## **A46 Newark Bypass – Development Consent Order (DCO) Application**

### **A46 from Farndon Roundabout to Winthorpe Roundabout, near Newark-On-Trent**

#### **Deadline 2 (12 November 2024) – Written Representations**

Drawing file: TR010065 / TR010065-000154-TR010065_A46 Newark Bypass_6.2 Figure 2.2 - Environmental Constraints Plan.pdf

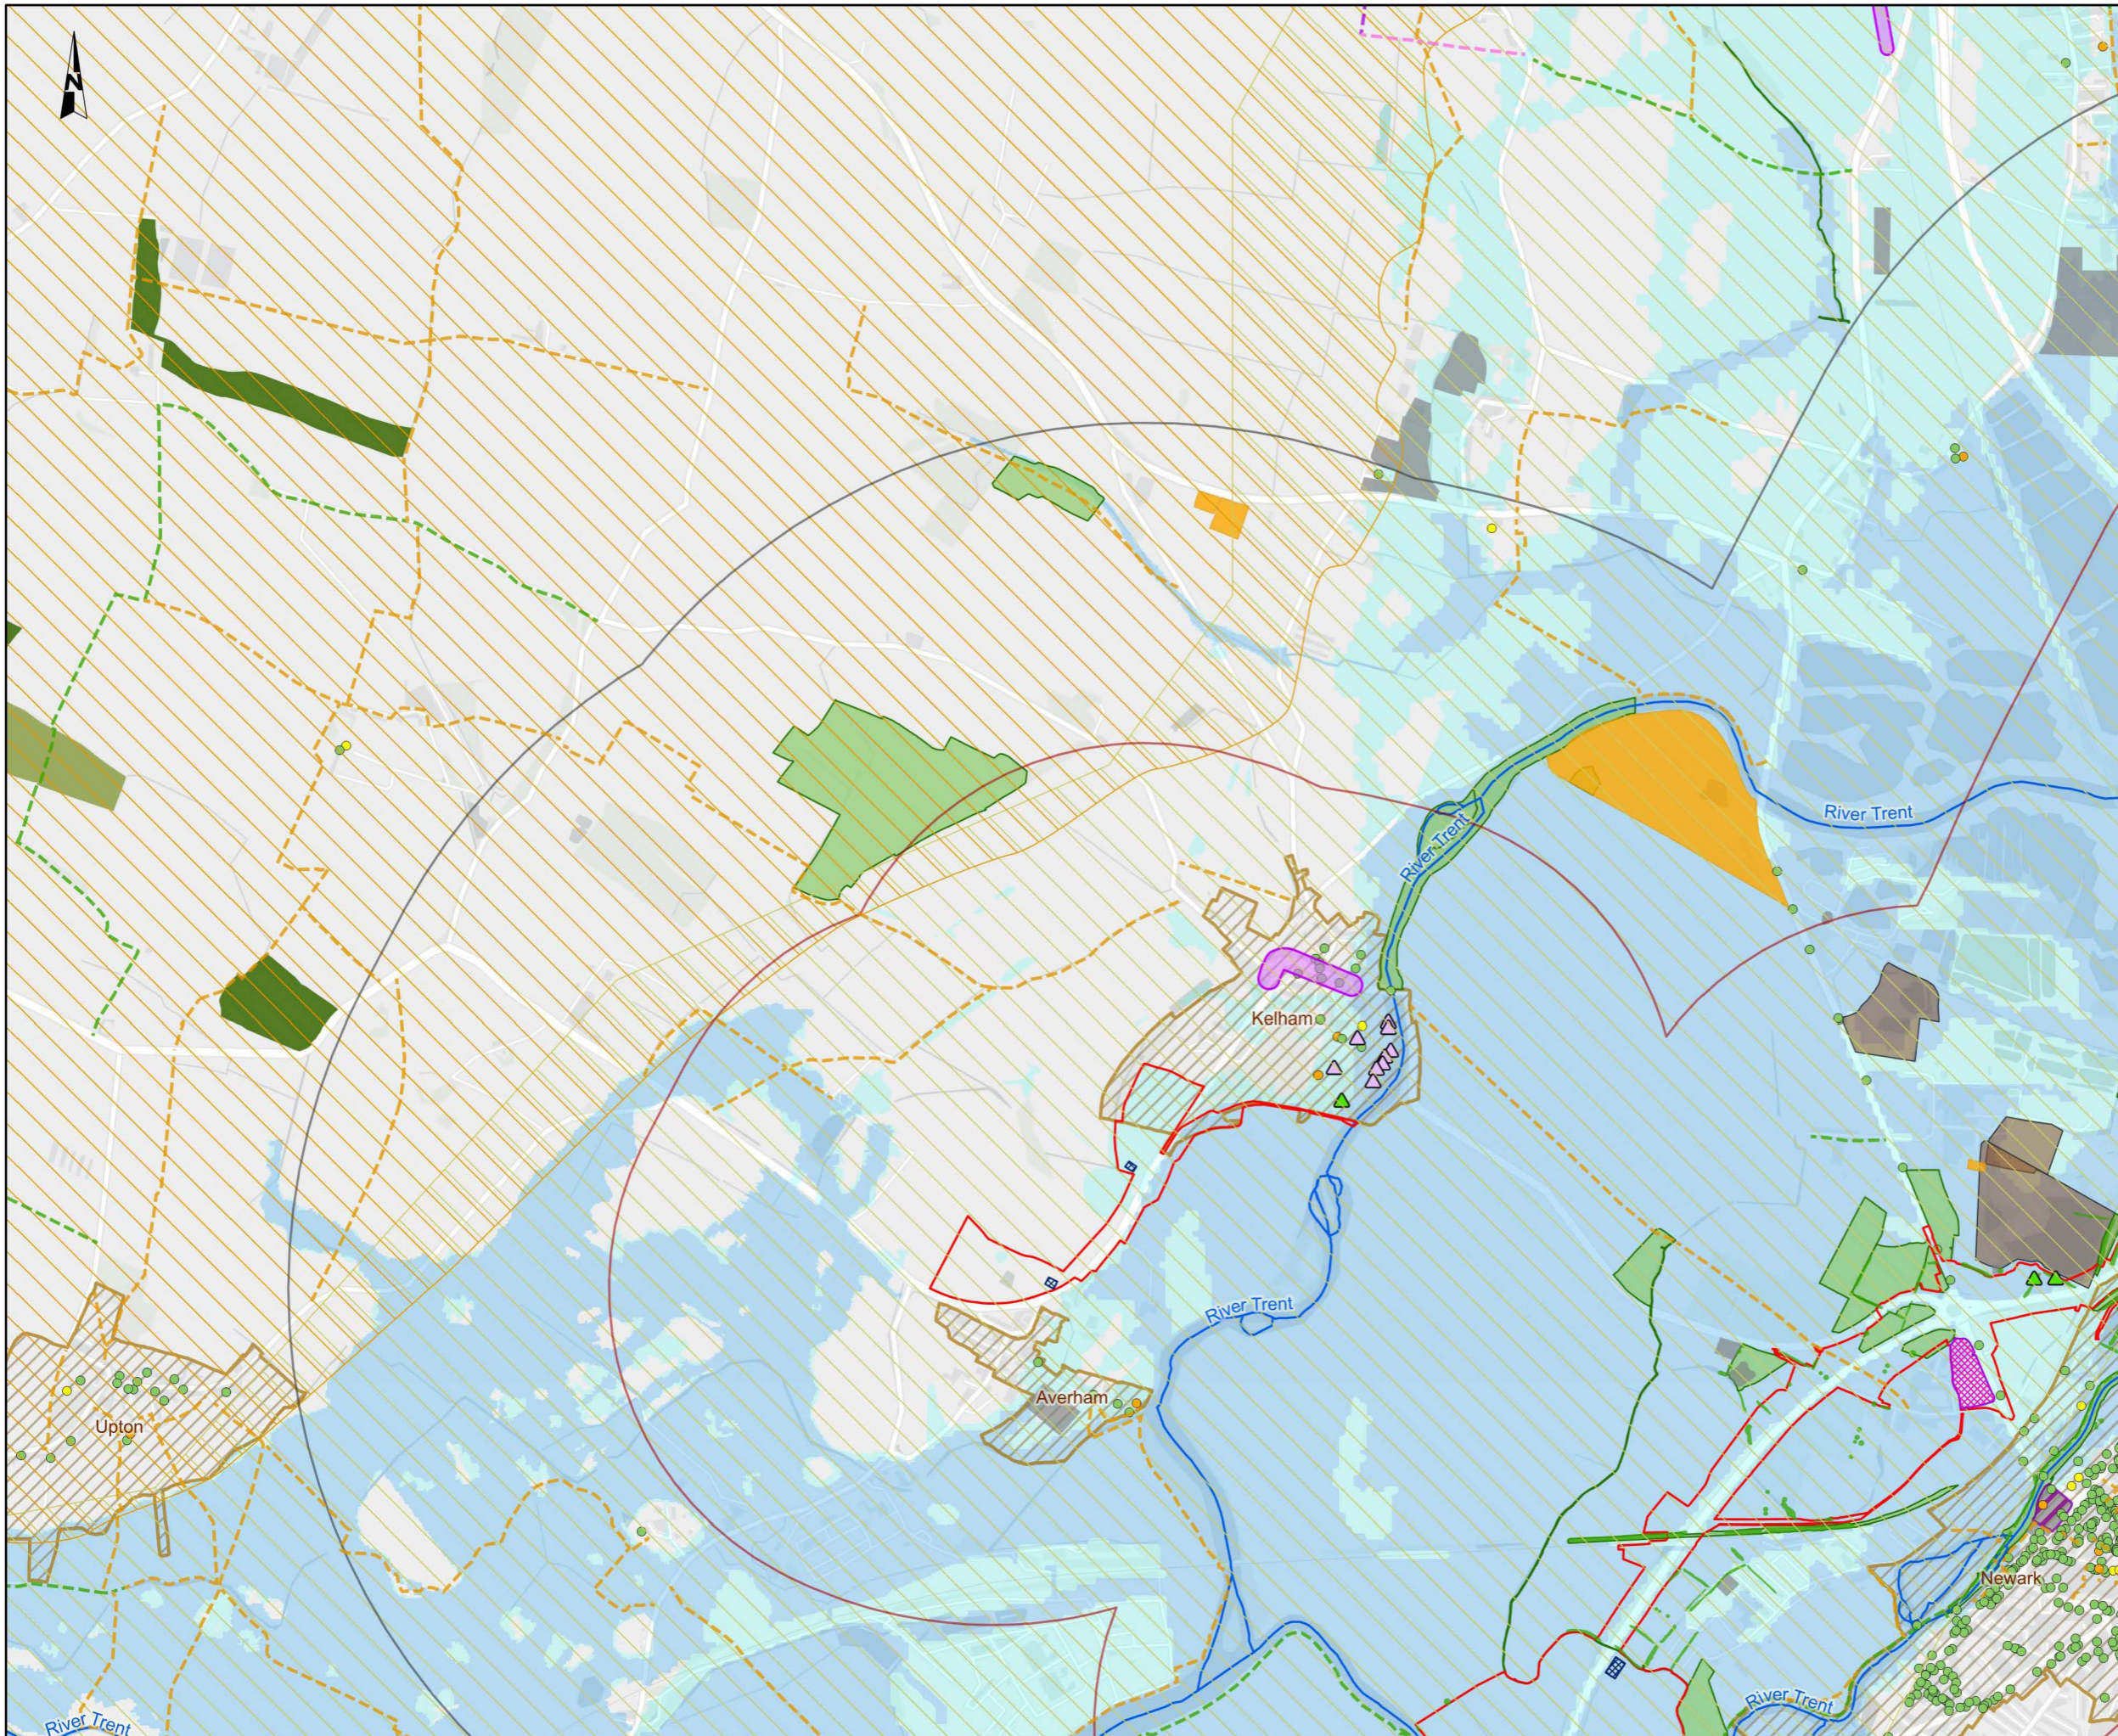
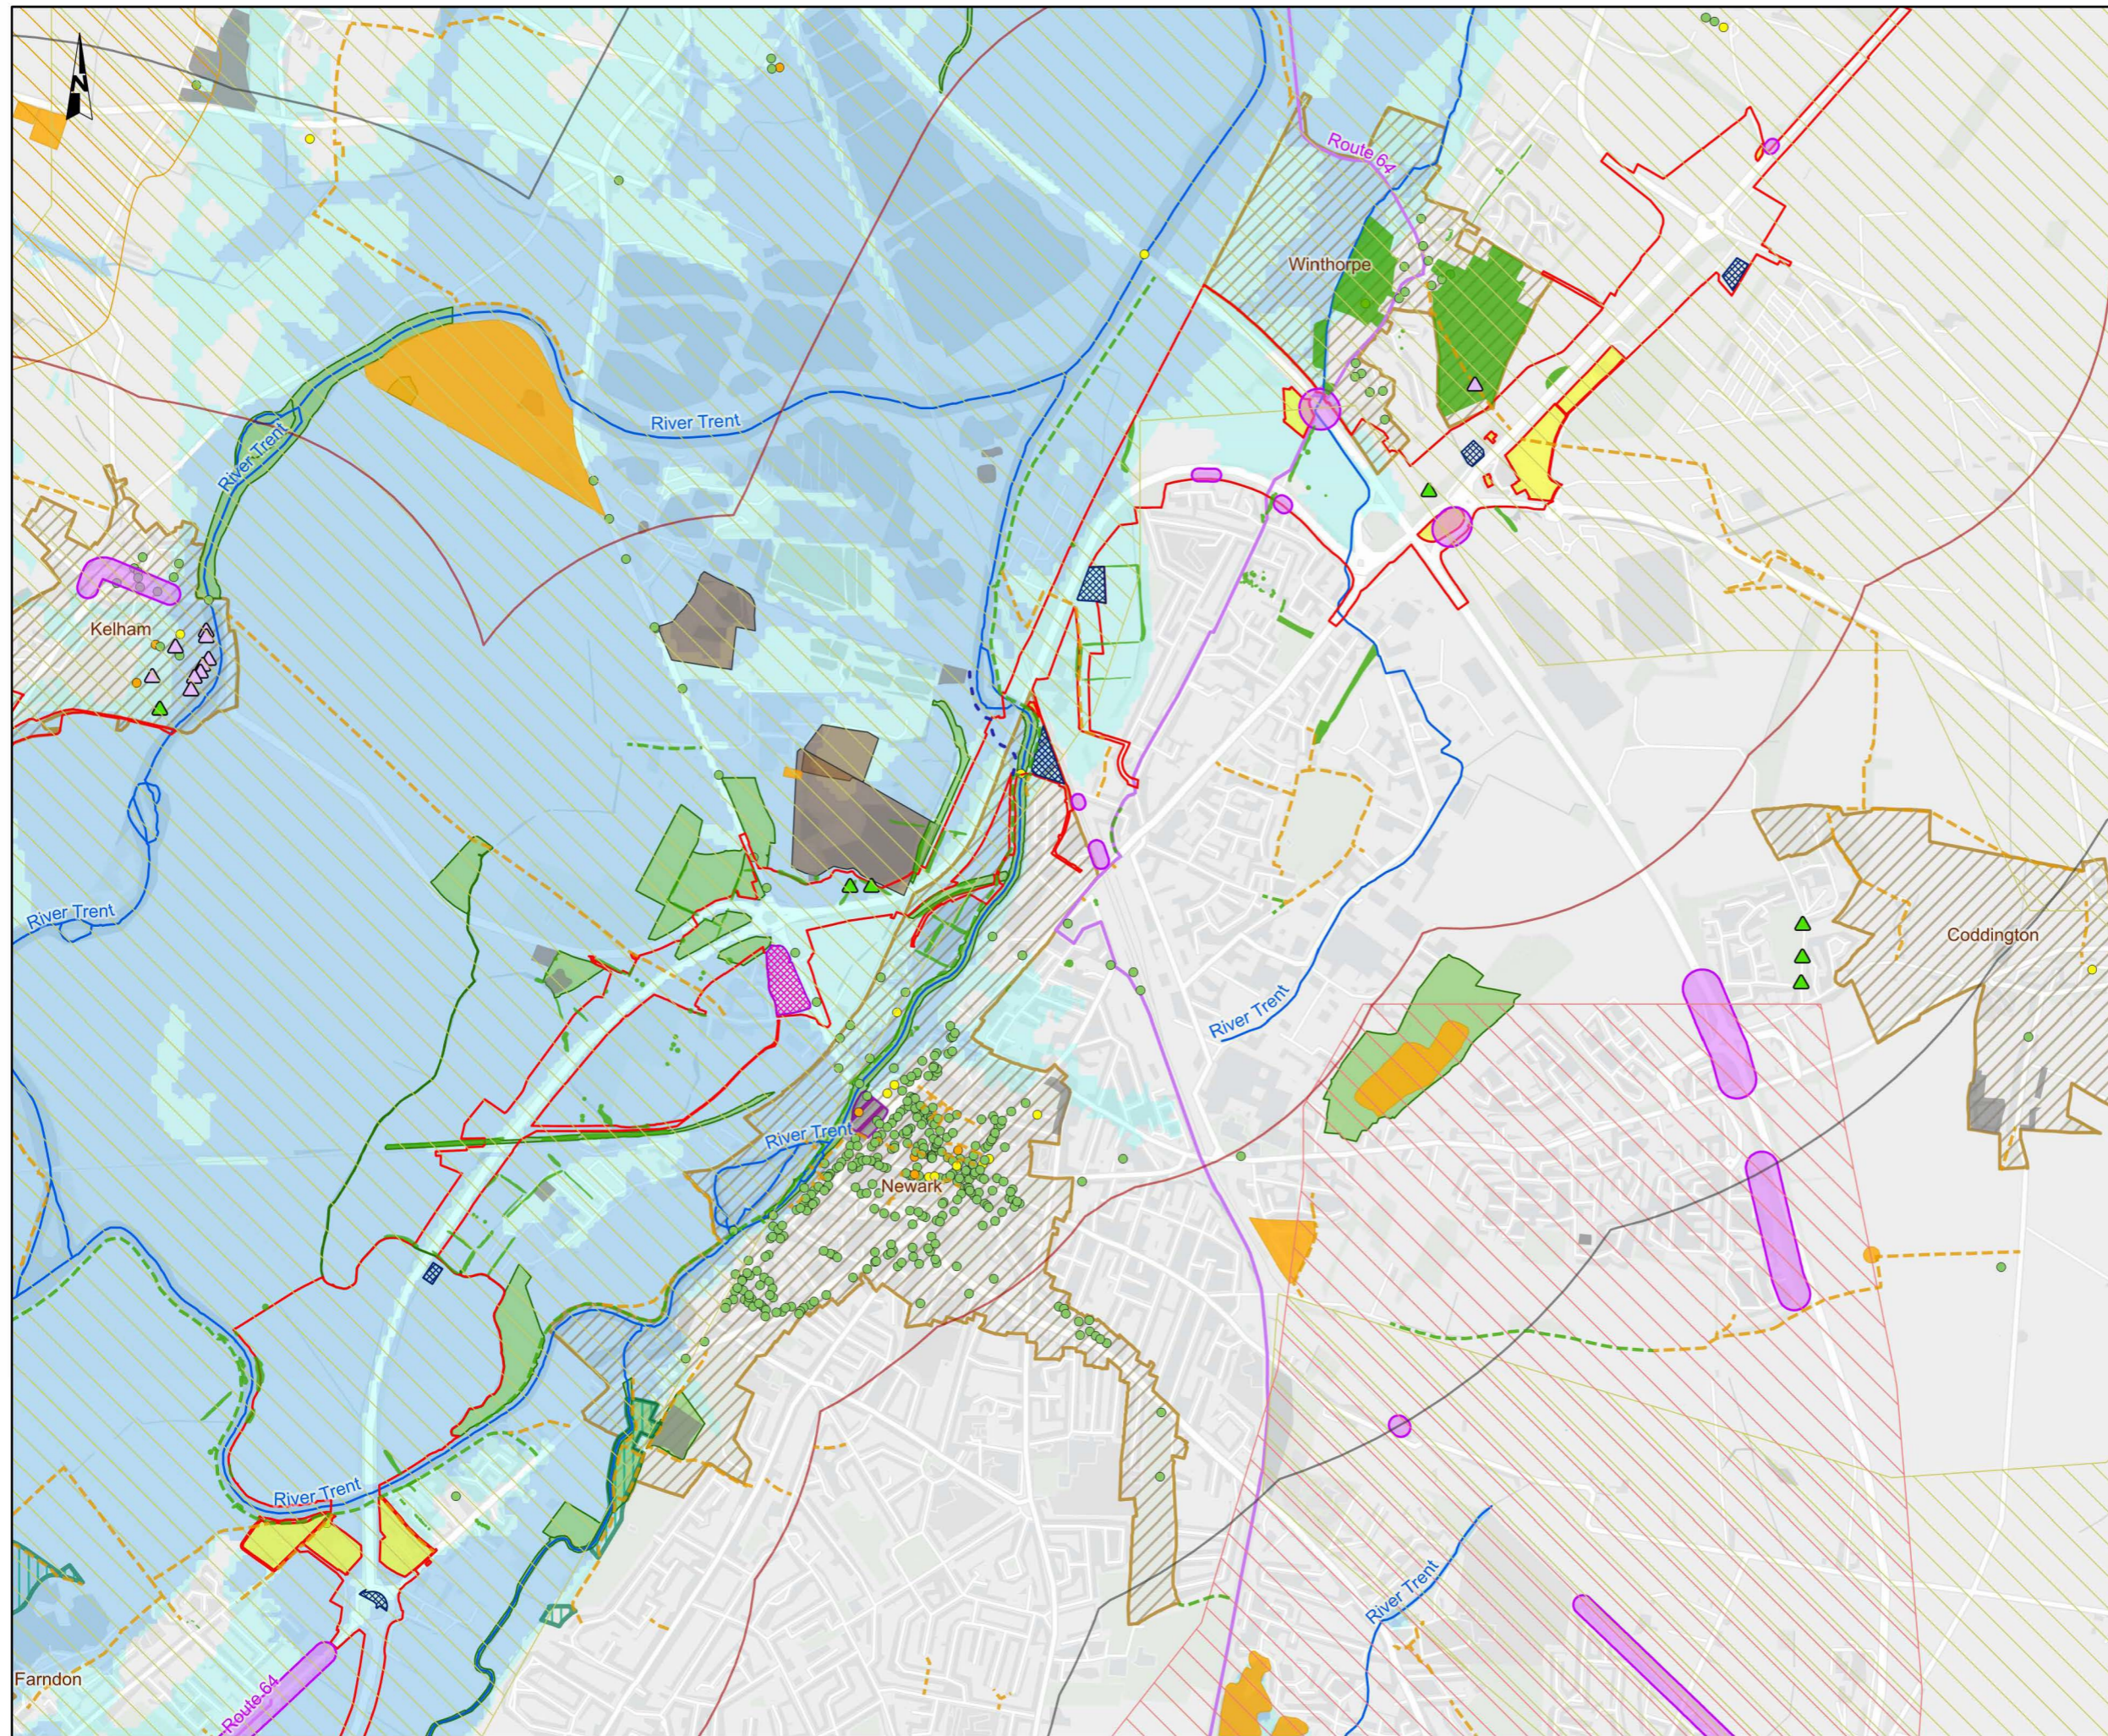
- **Contaminated land assessment**  
We are awaiting an updated Environmental Constraints Plan to be submitted at Deadline 2 in relation to issue EAGWCL-001 (British Sugar authorised (active) landfill site), and the submission of a Detailed Quantitative Risk Assessment (DQRA) and agreement of a satisfactory approach to addressing the contamination hotspot at WS46 (issue ref. EAGWCL-005).
